**Application:** DC/26/00298  
**Location:** EcoPower Suffolk Solar Project  
**Proposal:** Consultation on Application received by the Planning Inspectorate - Scoping Opinion for the EcoPower Suffolk Solar project

**Ecopower Suffolk Solar – BMSDC: EIA Scoping Report | Reference: DC/26/00298**

**Environmental Impact Assessment Scoping Report Reference: 302827-00/EIASR Issue P01 (23rd January 2026)**

Drawing Title
Figure 7.8 - Viewpoints and ZTV - Overview - Sheet 1 of 6

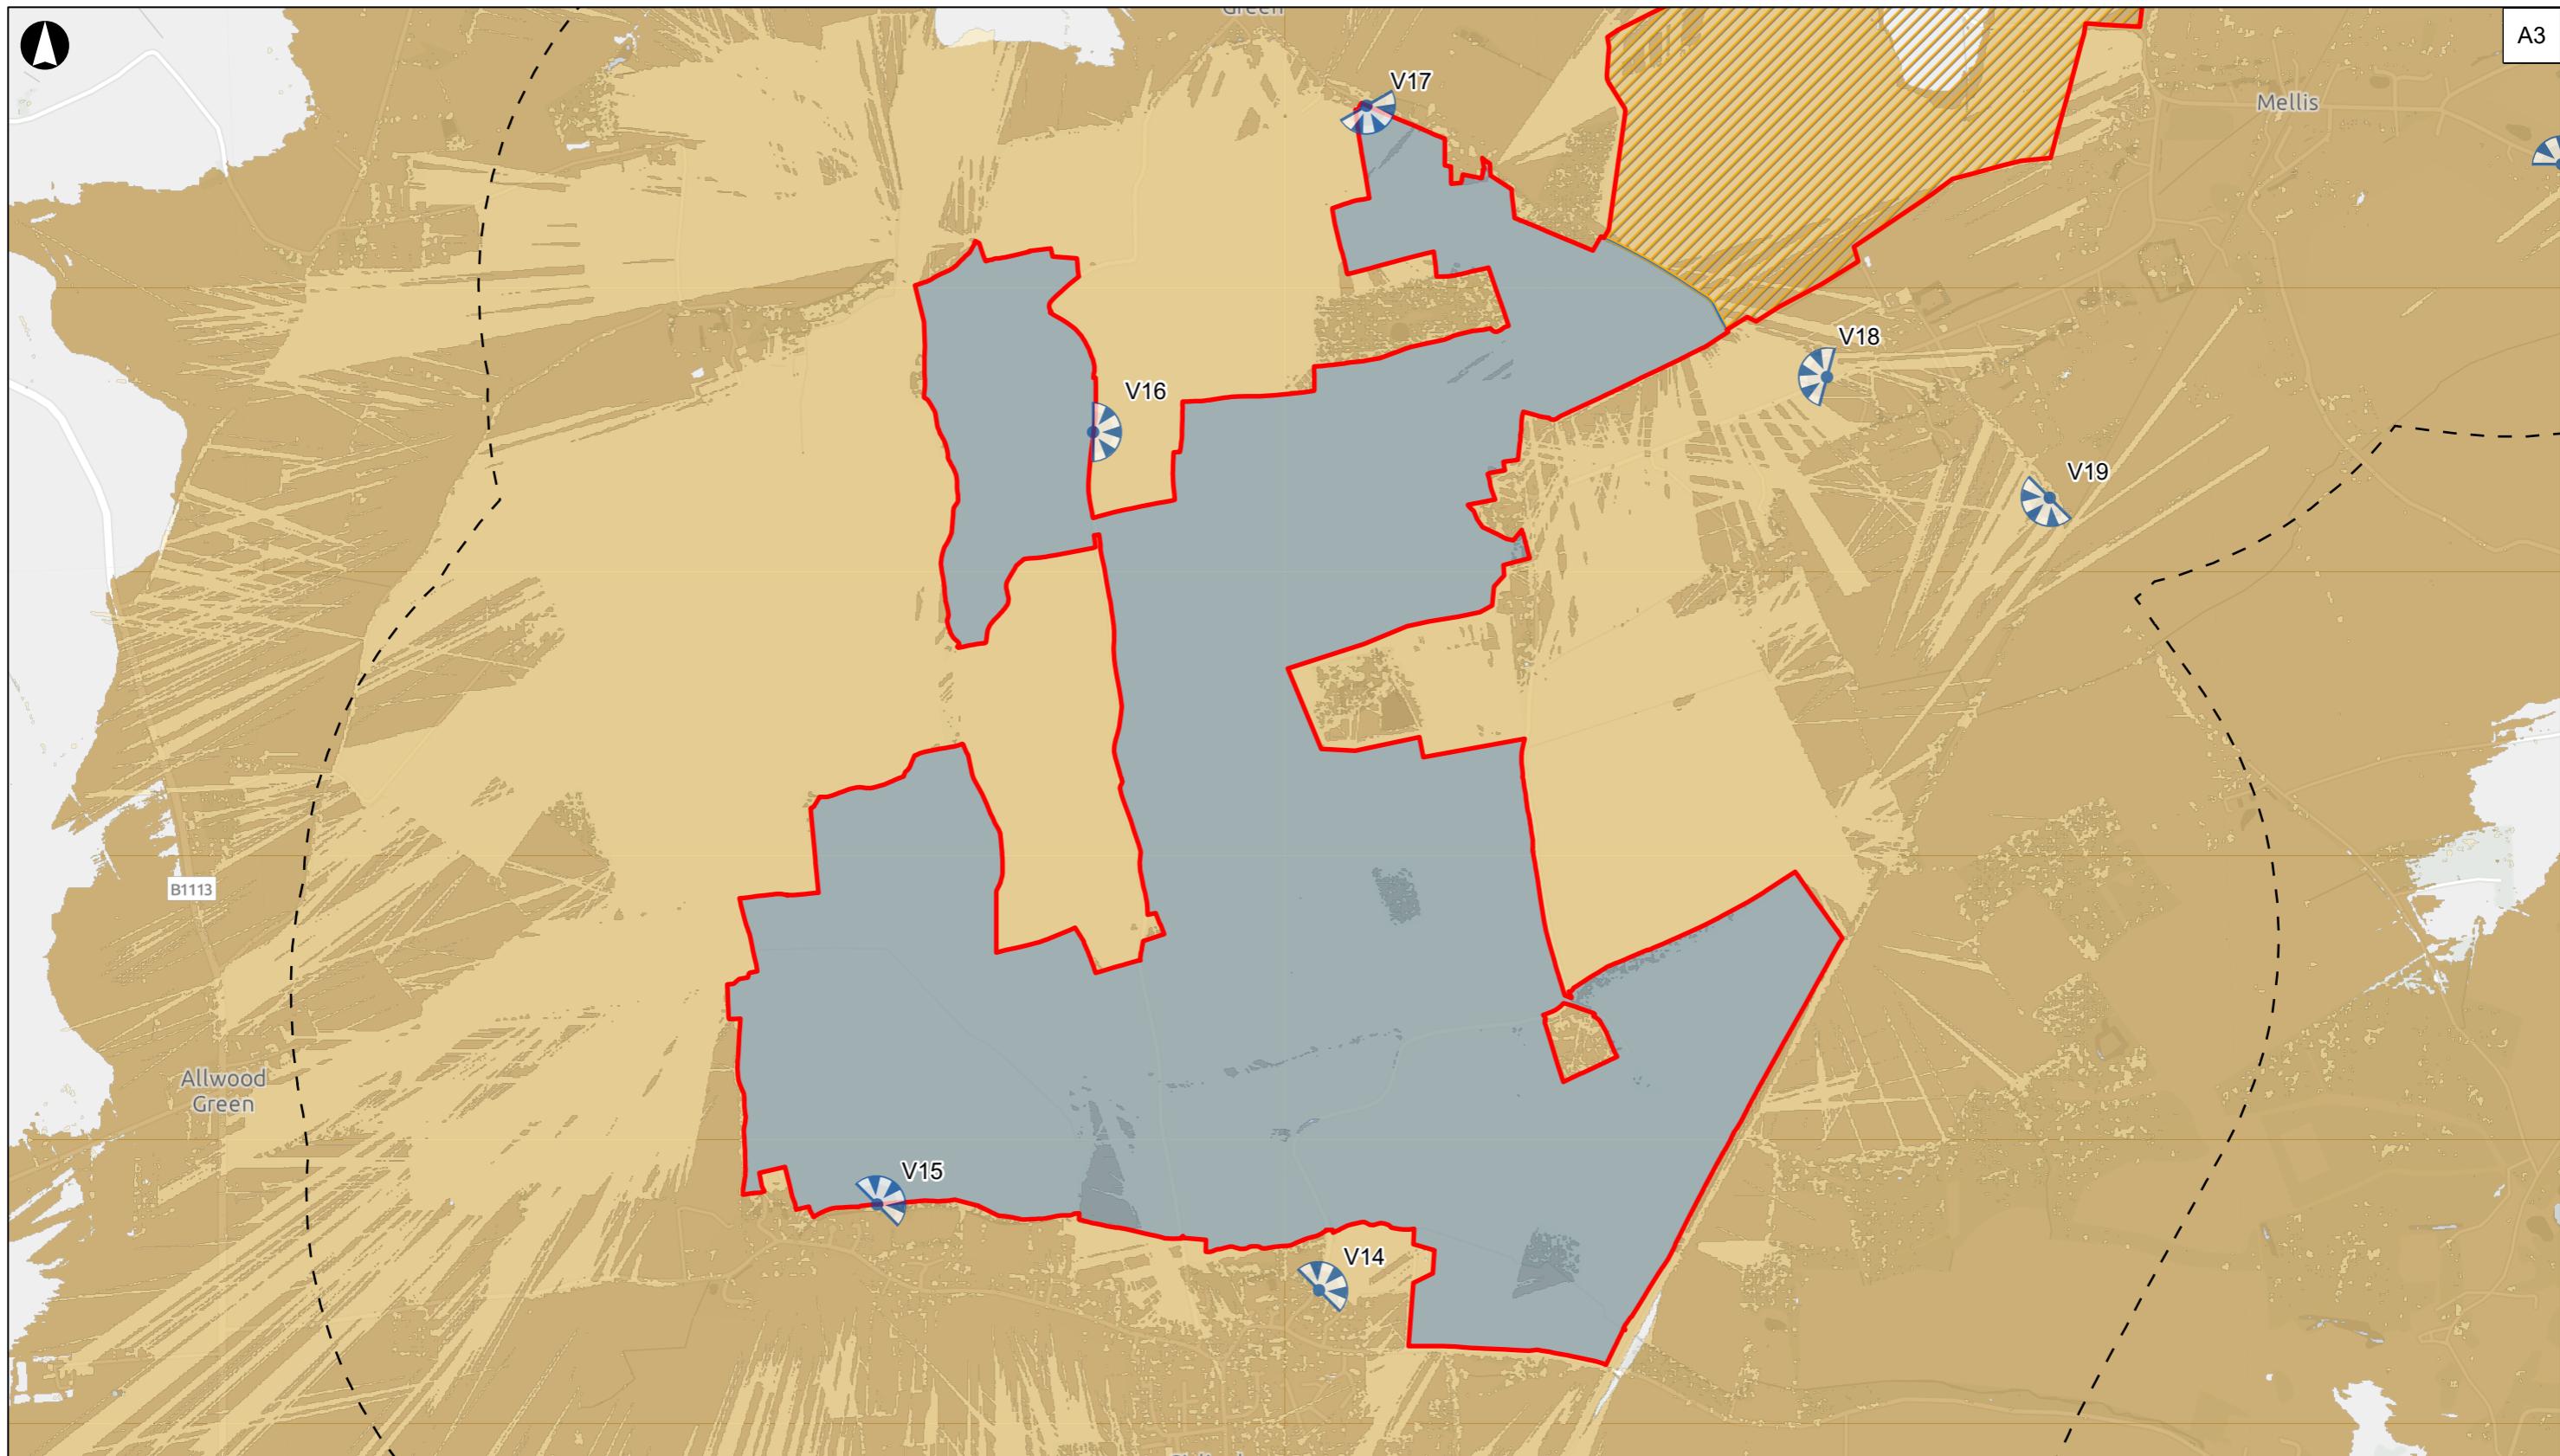
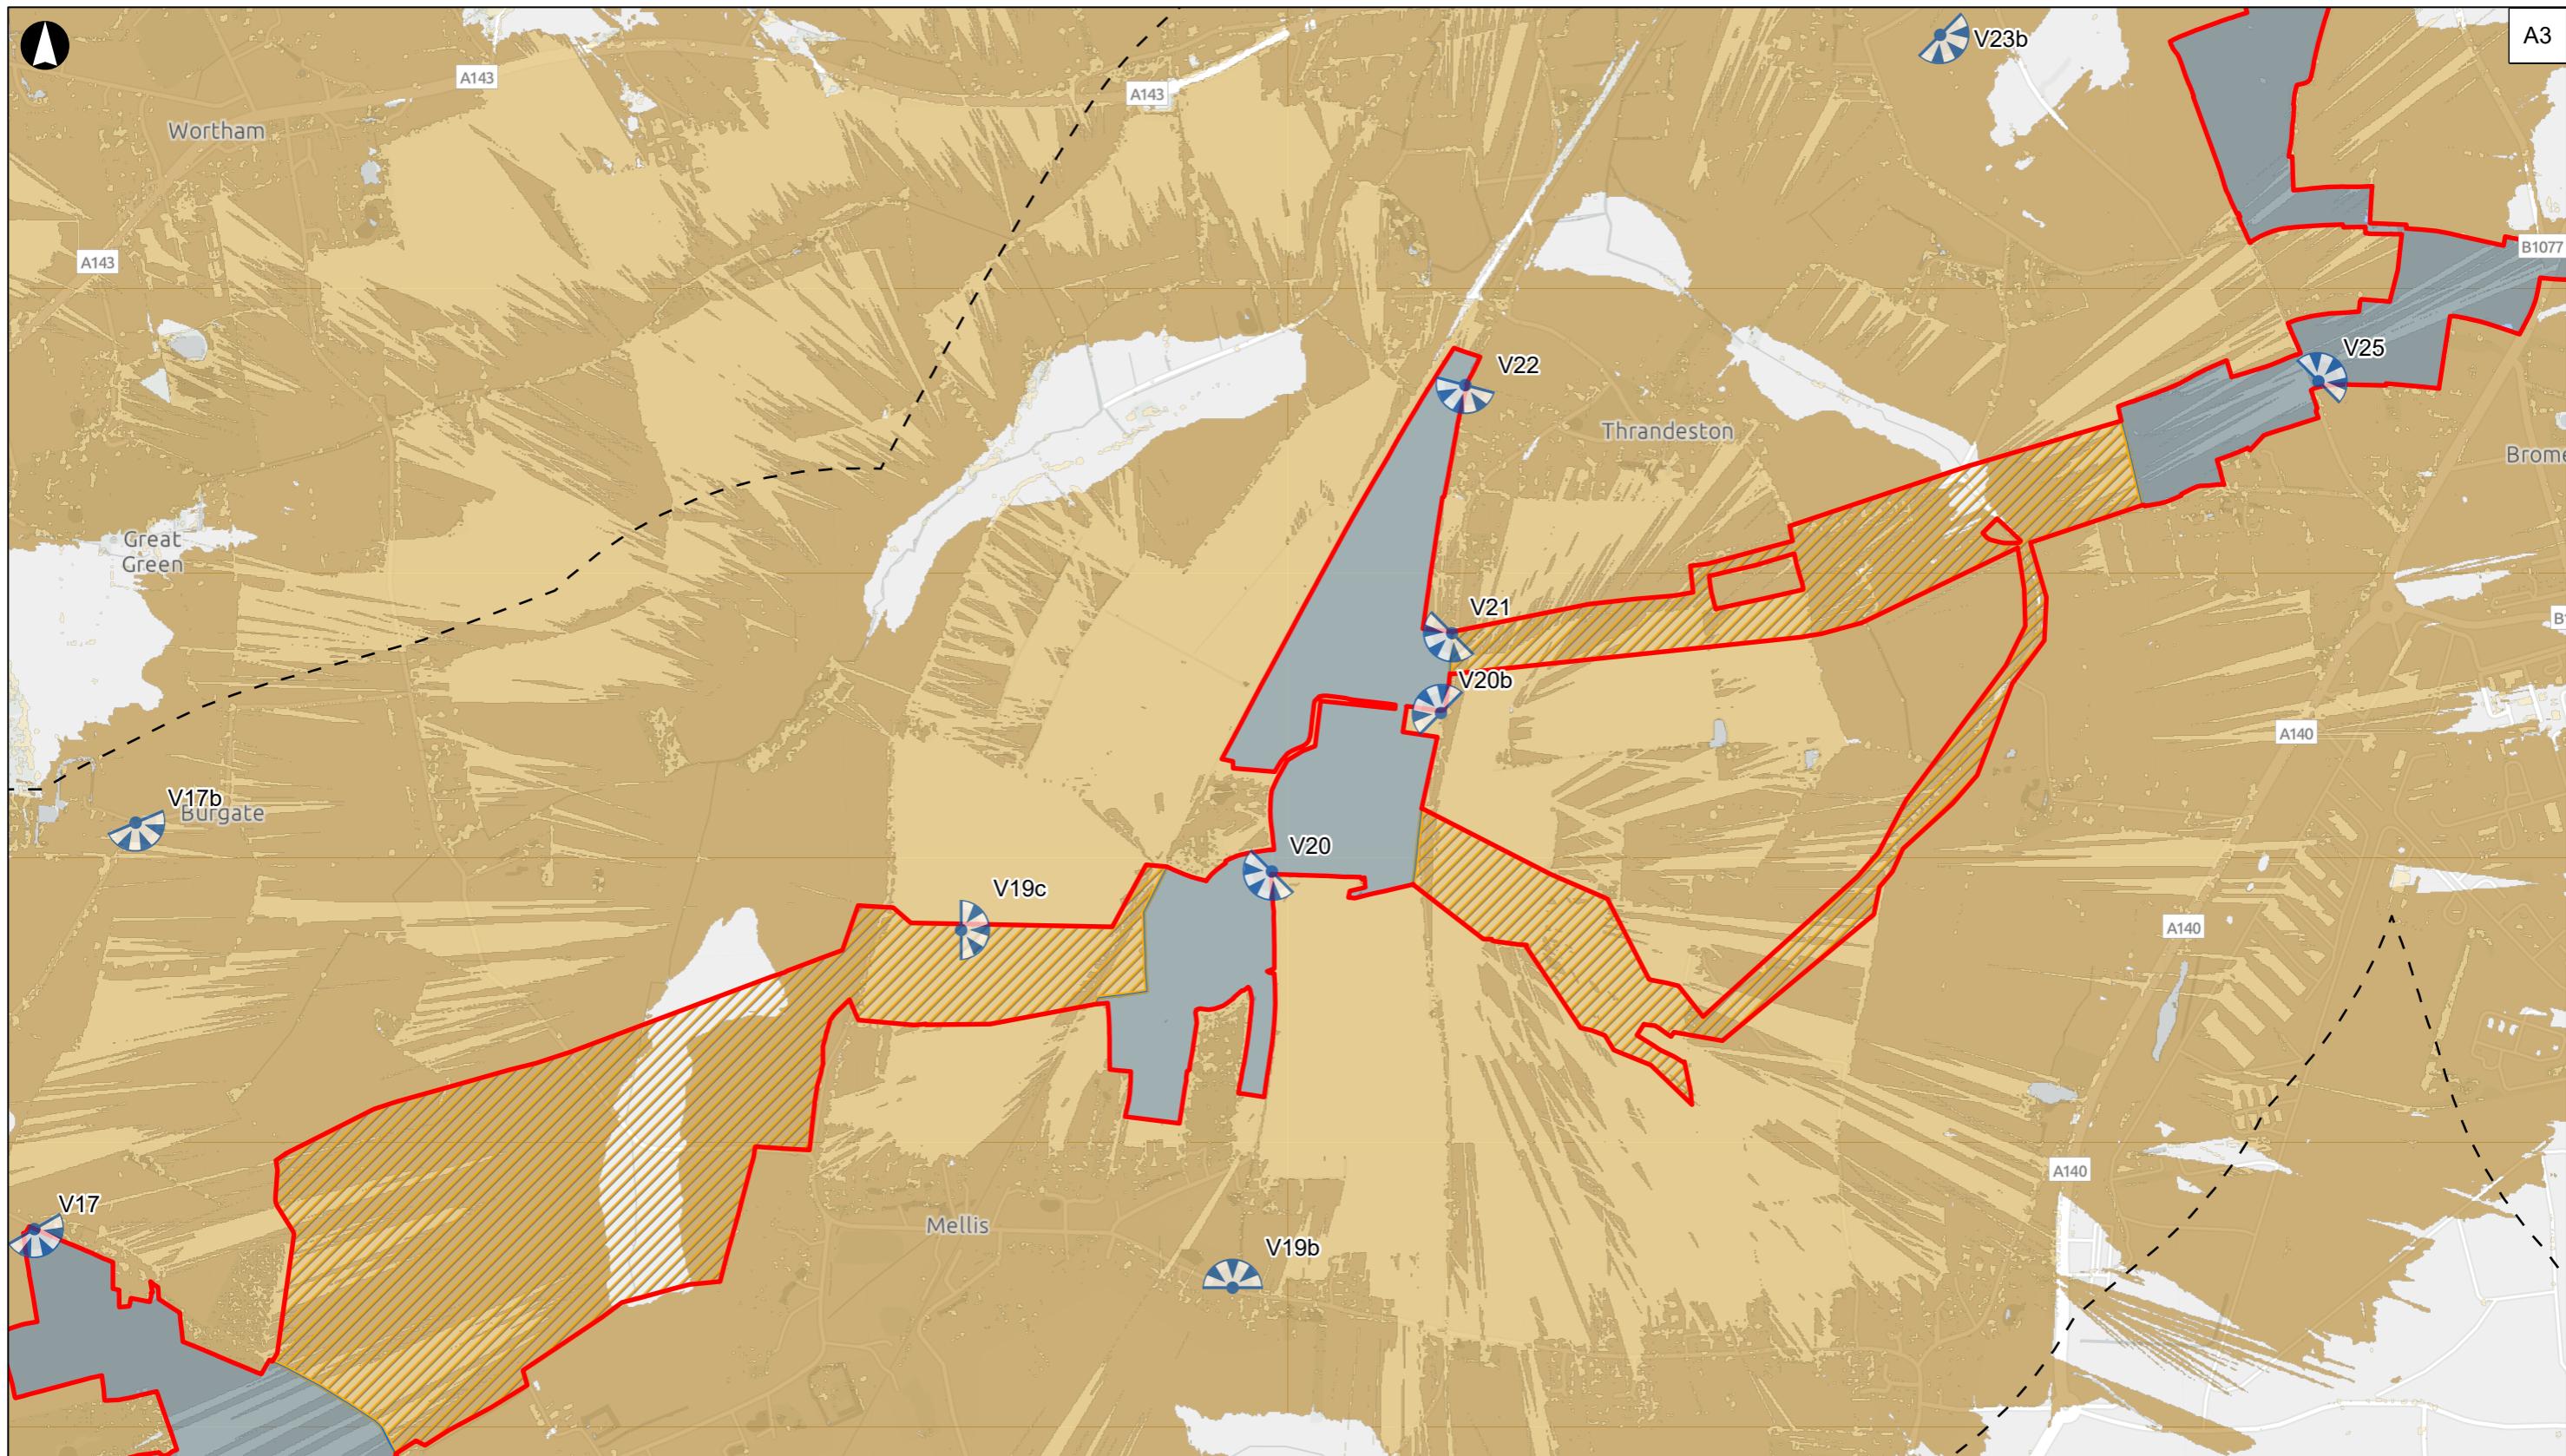
and we support the suggested criteria including consideration of physical and historic connectivity and relationships with other sites and the wider landscape as well as the Proposed Development's Zone of Theoretical Visibility which is shown in Figure 7.8. We note further that it is anticipated that Scheduled Monuments and Grade I and Grade II\* listed buildings located within the Study Area and within the ZTV are considered likely to be the most sensitive to changes within their setting based on the EIA methodology (though what value/sensitivity is to be assigned to these assets has not yet been set out).

- 1.11. We note the proposed viewpoint locations and directions shown on Figure 7.8 but consider that there should be additional viewpoints and visualisations to specifically inform the assessment of impact on the setting and significance of heritage assets.

- 1.12. Views looking towards and out from Mellis Conservation Area would be a key priority due to the proximity to Area 3 Gislingham and Area 5 Thrandeston and Mellis, including views from and towards the listed buildings located at the western end of the Conservation Area:

- Grade II Marsh Farmhouse (List entry number 1032768) – located to the north-west of Area 5 Thrandeston and Mellis
- 1.15. Further viewpoints and visualisations should be provided looking out from and towards the Thrandeston Conservation Area which is located to the east of Area 5 Thrandeston and Mellis. The following listed buildings are located at the western edge of the Conservation Area for which viewpoints and visualisations should be provided:
